**KIRKLEES METROPOLITAN COUNCIL
INVESTMENT & REGENERATION SERVICE**

Reference No:	2026/62/90574/W
Site Address:	37, Sylvan Ridge, Huddersfield, HD2 1ZH
Description:	Demolition of existing conservatory and erection of part first floor/part two storey side extension, two storey rear extension and loft and garage conversion with associated alterations
Recommending Officer:	Nicole Helliwell

Officer Report

CLIENT :	Mahmood		
ADDRESS :	37 Sylvan Ridge Huddersfield HD2 1ZH		
PROJECT :	Proposed Elevations.		
DATE :	Feb 2026		
ISSUE :	PLANNING:	B.REGULATIONS:	GENERAL:
	<input checked="" type="radio"/>	<input type="radio"/>	<input type="radio"/>
DRAWING REF :	REVISION:	SCALE:	
2205-26-003	B	1-50@A1

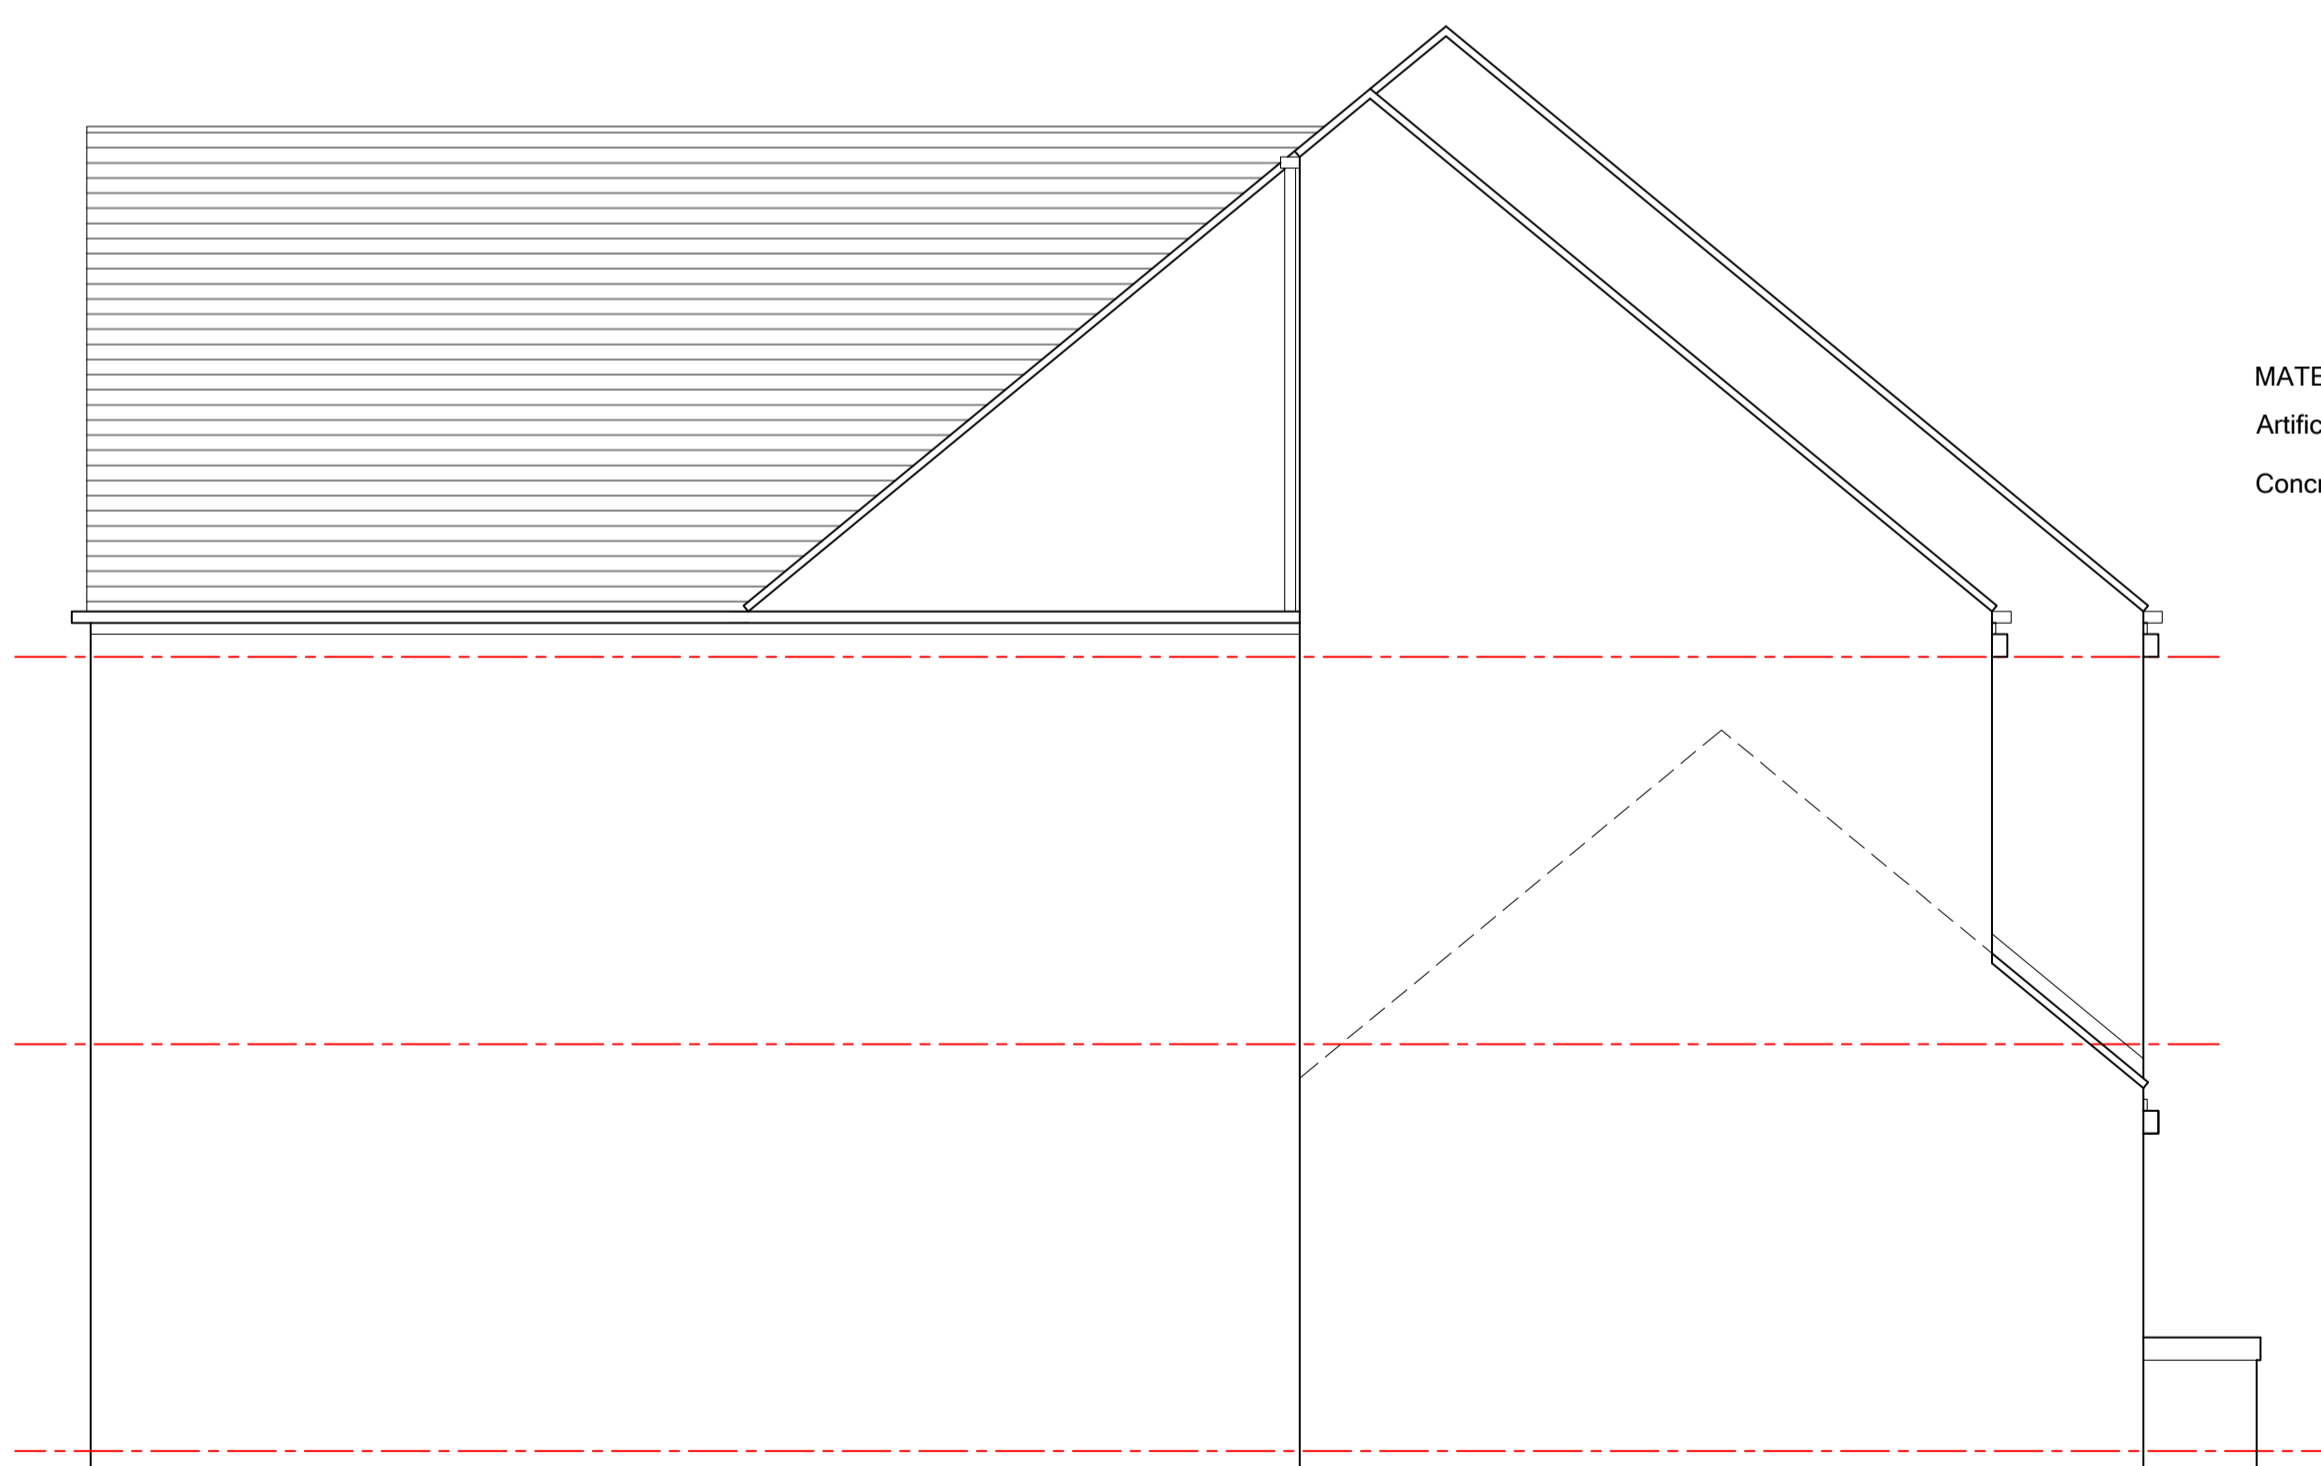
The proposed part first floor/part two storey extension would project approximately 2.7m – 2.95m from the side elevation of the original build and would partially sit above the existing single storey element of the property. The extension would be faced in artificial stone and would incorporate a dual-pitched roof finished in concrete tiles to match the appearance of the host dwelling. The enlargement would be a proportionate addition and would be set back approximately 1m from the principal elevation of the dwelling. However, due to its siting and design, the proposed extension would form an incongruous addition which would appear prominent from public vantage points along Sylvan Ridge and would unbalance the link detached pair.

Although the proposed extension would be partially set down from the ridge and back from the front elevation of the host property, it would result in the closure of the gap between the application property and link detached neighbour due to its first floor location and projection up to the shared boundary. This would result in a harmful erosion of space between the properties, with the potential for the creation of a terracing effect should a similar proposal be sought by occupiers of No.35, which would become difficult to refuse. At present, from the time of the officer's site visit and a review of planning history, all dwellings of this house type on this development remain as per their original design, linked by garages at the ground floor level with uniform gaps between the dwellings, creating a sense of space which is a characteristic of the street scene.

The proposed part first floor/part two storey side extension, by reason of its scale, siting and design, would be a prominent incongruous addition which would unbalance the link detached pair and would disrupt the uniformity of the immediate building group. The enlargement would detract from the character and appearance of the host property and wider street scene and would be contrary to Policy LP24 of the Kirklees Local Plan, the House Extensions and Alterations Supplementary Planning Document and Chapter 12 of the National Planning Policy Framework.

1. The proposed part first floor/part two storey side extension, by reason of its siting and design, would be a prominent incongruous addition which would unbalance the link detached pair and would disrupt the uniformity of the immediate building group. The enlargement would detract from the character and appearance of the host property and wider street scene and would be contrary to Policy LP24 of the Kirklees Local Plan, the House Extensions and Alterations Supplementary Planning Document and Chapter 12 of the National Planning Policy Framework.

2205-26-002 C 1-50@A1

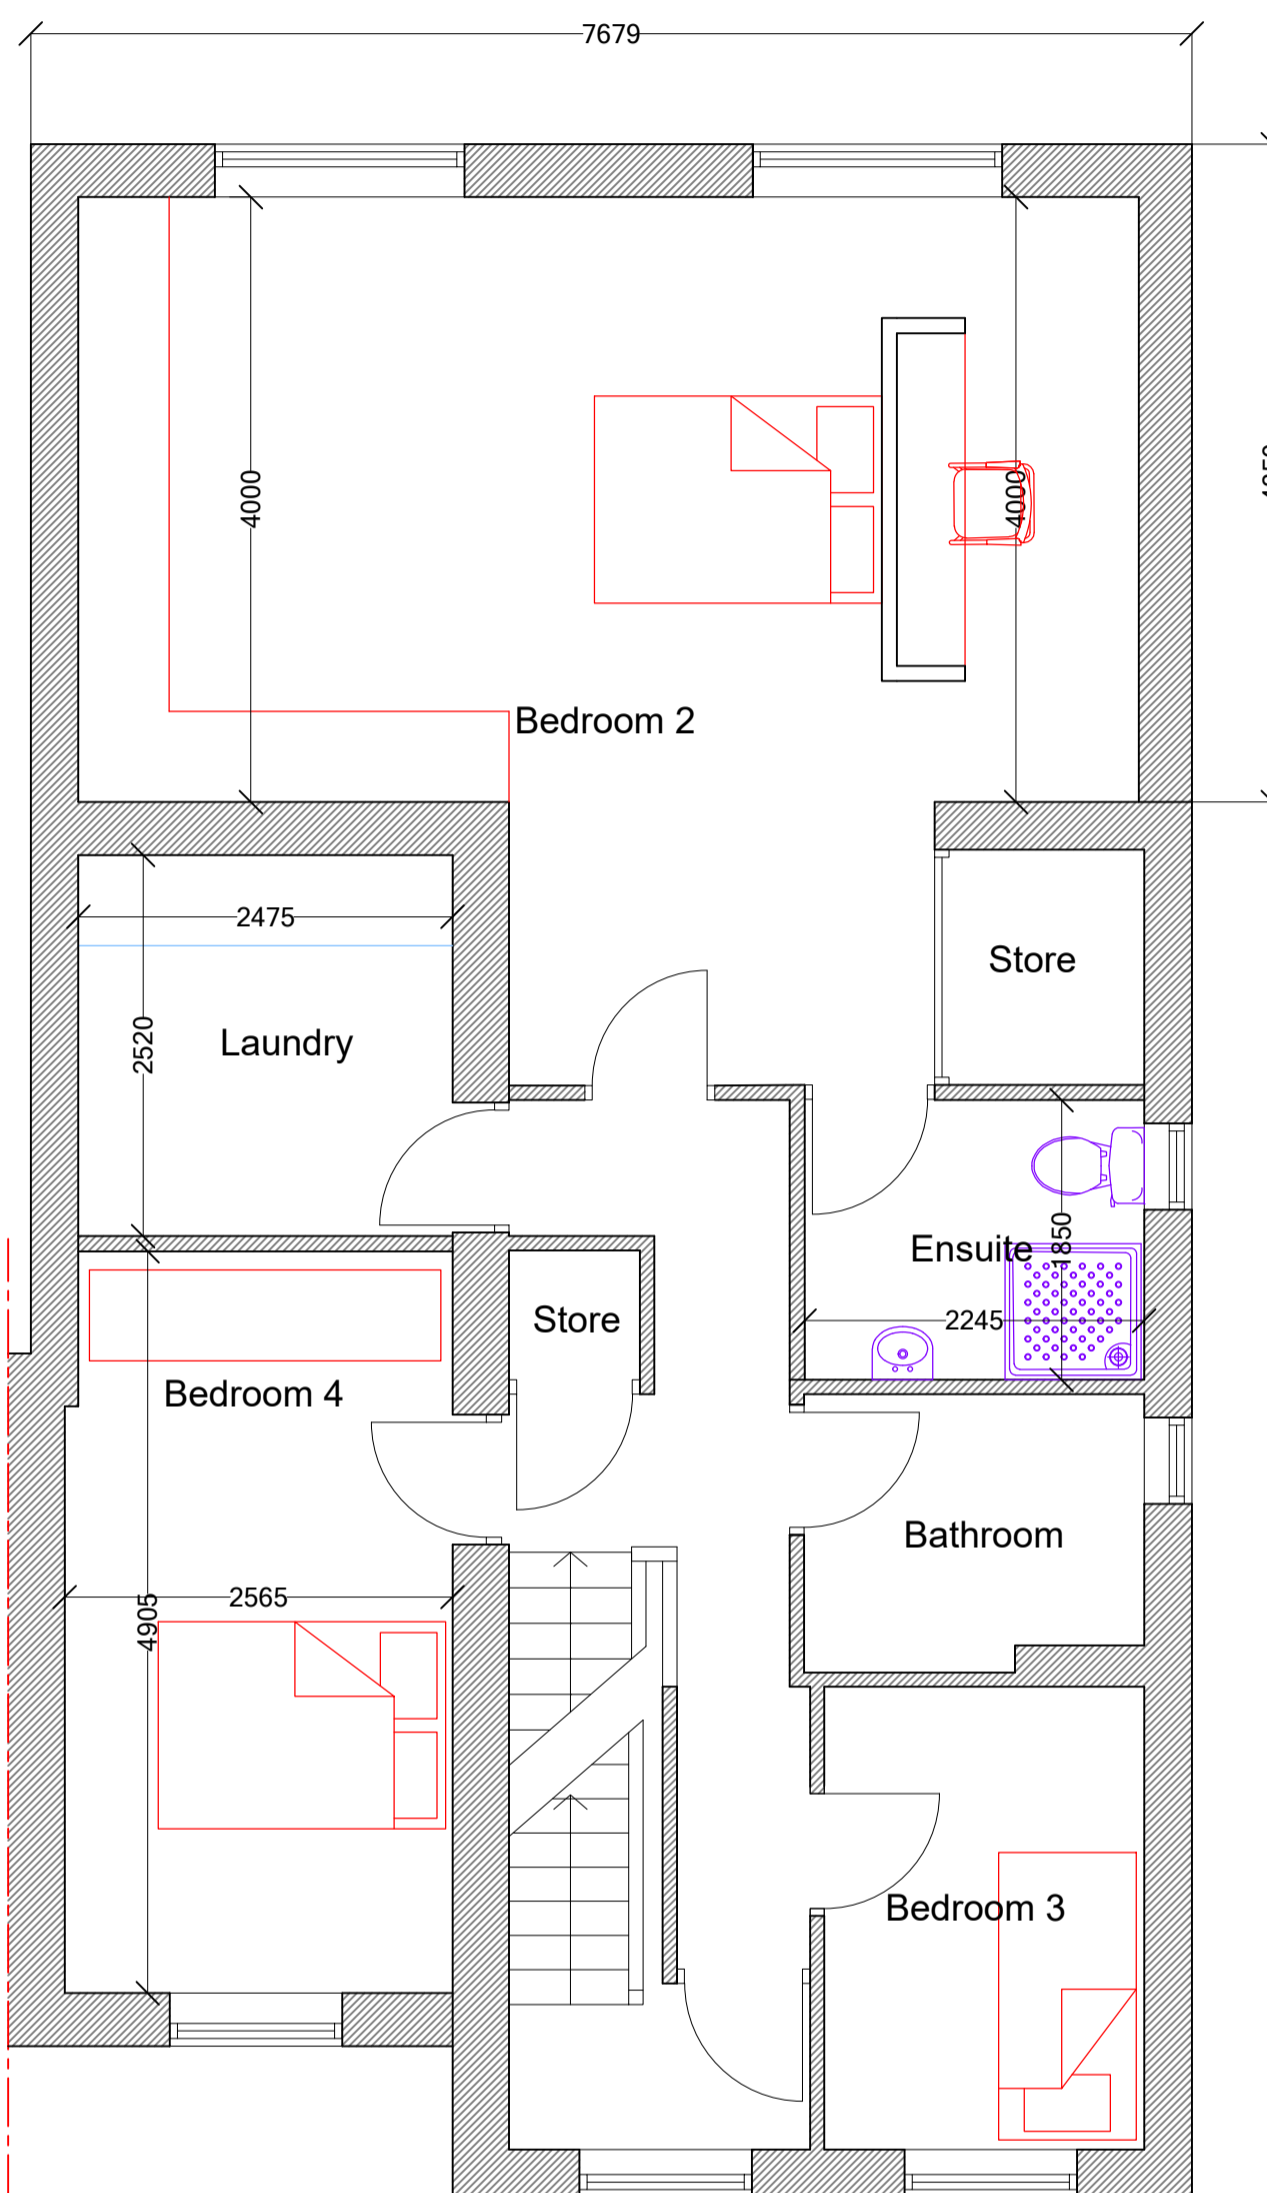
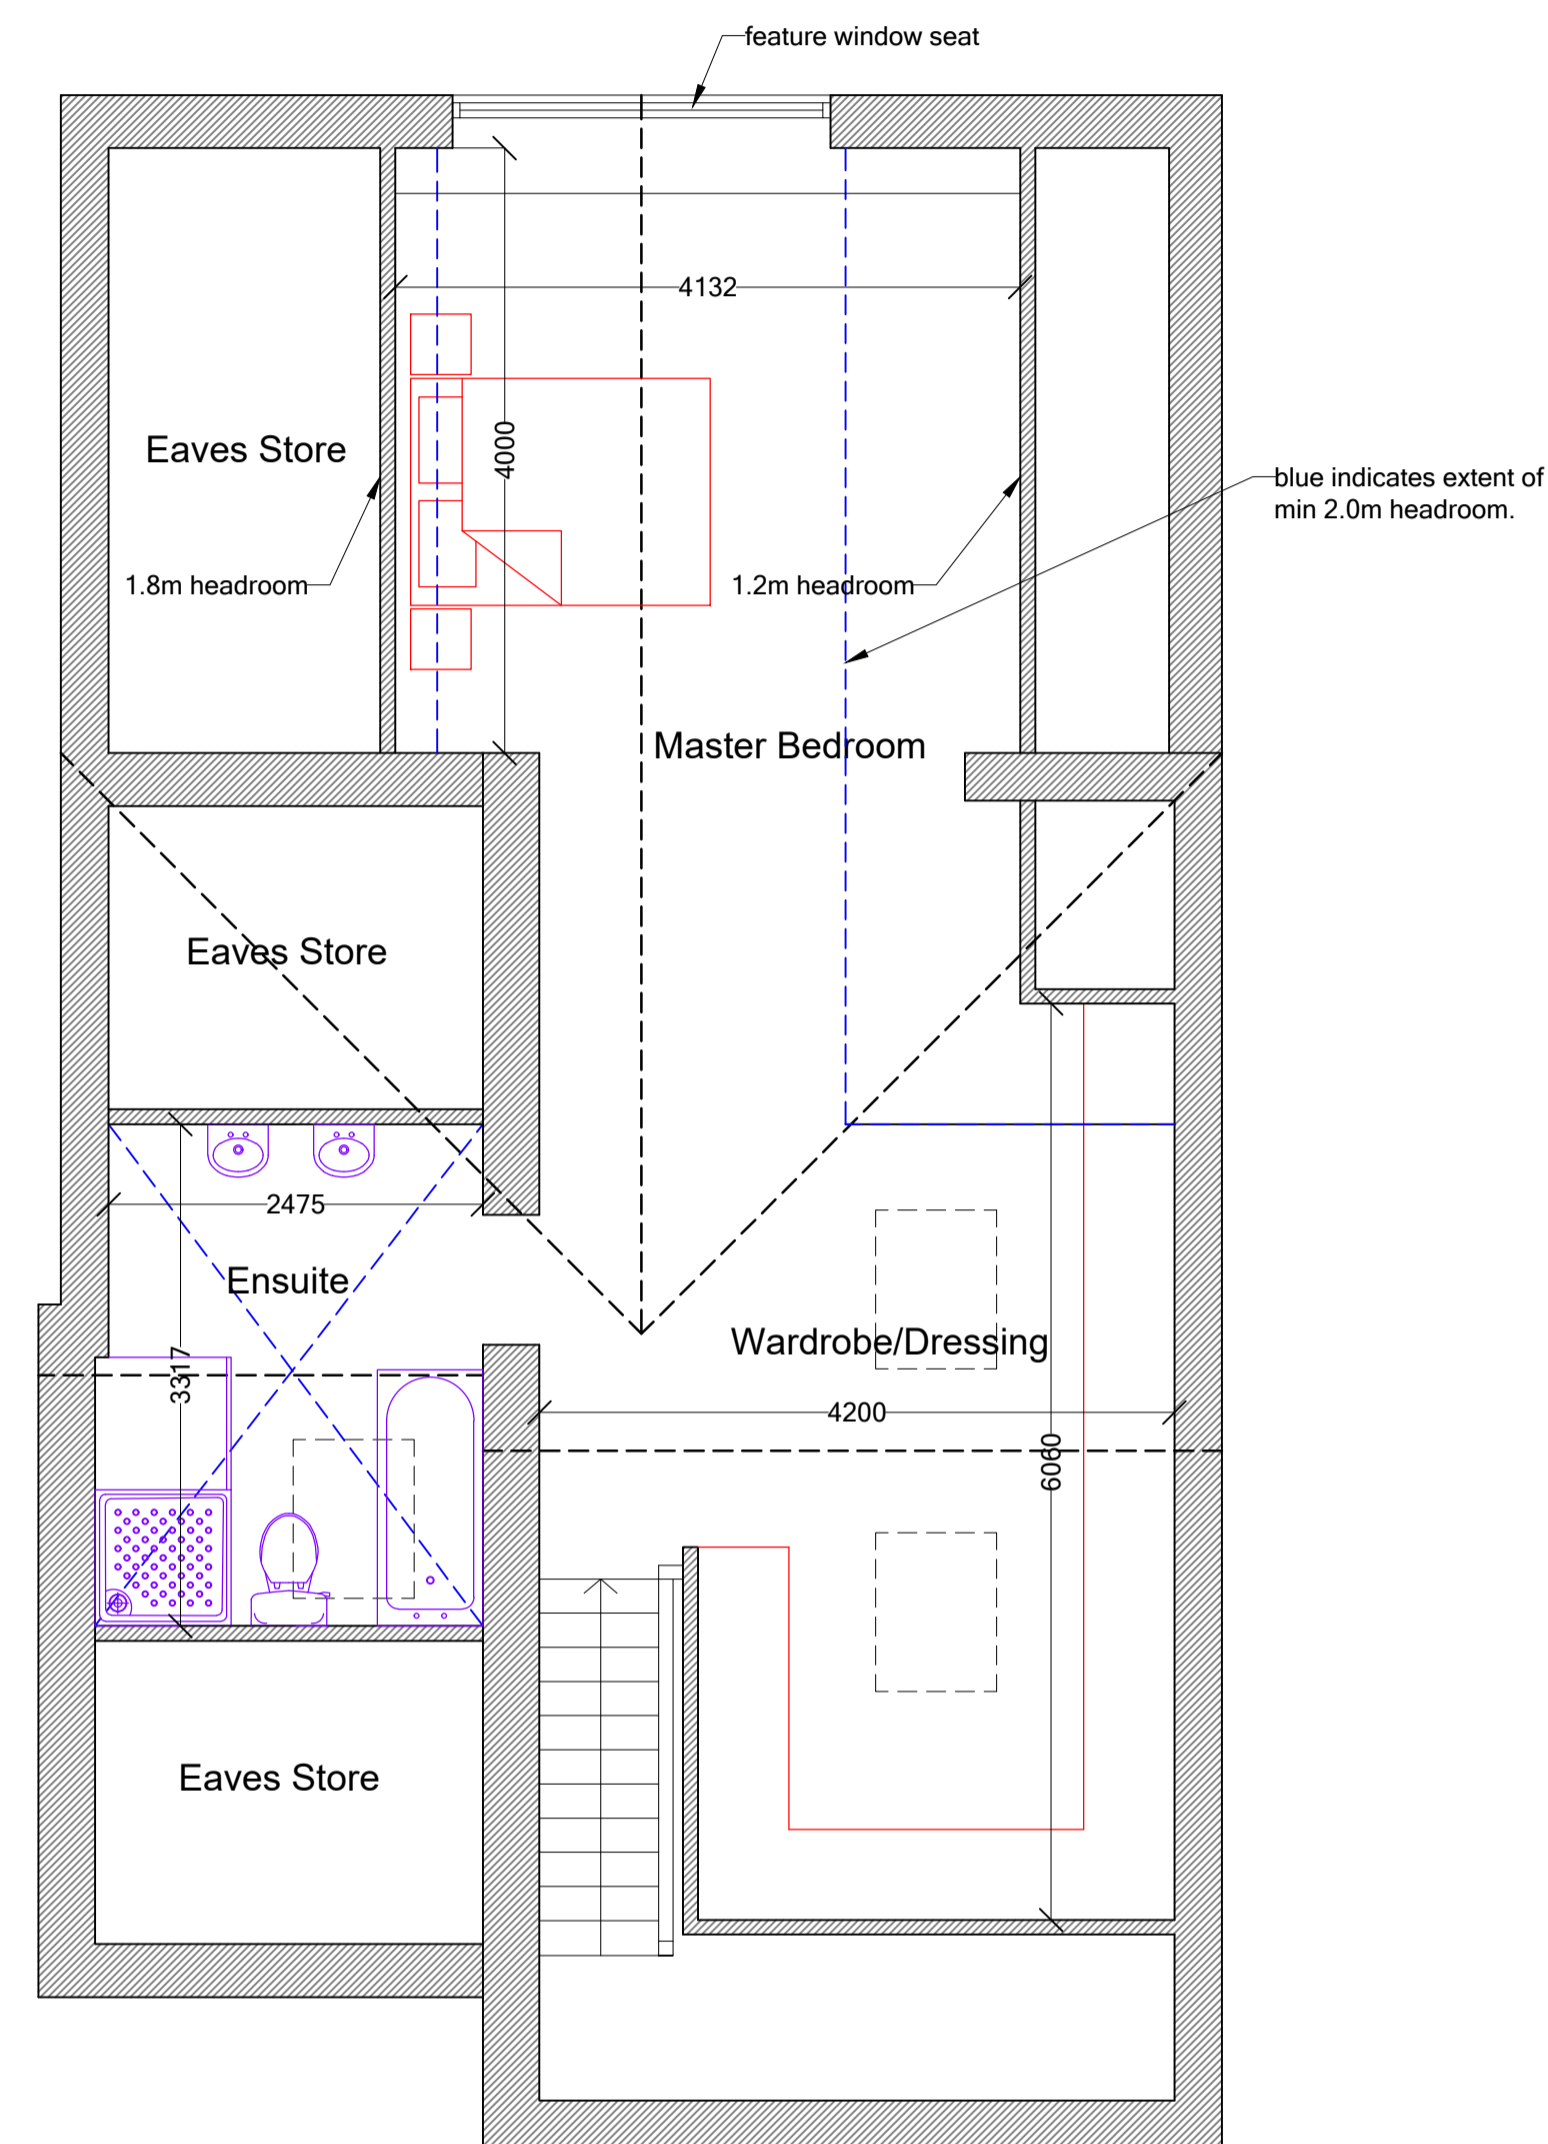
The submitted plans confirm that the existing garage would be converted to a snug as part of the application. The proposed external alterations would see the existing garage door removed and a new window installed within the front elevation of the dwelling. Given that the fenestration would be appropriately designed and would be in keeping with the style of the original build, it is considered that the proposed alterations would respect the visual amenity of the host dwelling and the surrounding area.

The proposal would create an additional bedroom, which would intensify the domestic use at the property. The Kirklees House Extensions and Alterations SPD states that three off street parking spaces would need to be provided for a four bedroomed dwelling. Whilst the existing two parking spaces within the driveway would be retained, the submitted plans demonstrate that the garage would be converted to living accommodation as part of the application which would result in a parking space being displaced.

Notwithstanding the above, it was evident at the time of the case officer's site visit that the area to the front of the dwelling is currently used for the parking of 3 vehicles and as such, a reason for refusal on this basis is considered to be unreasonable in this instance.
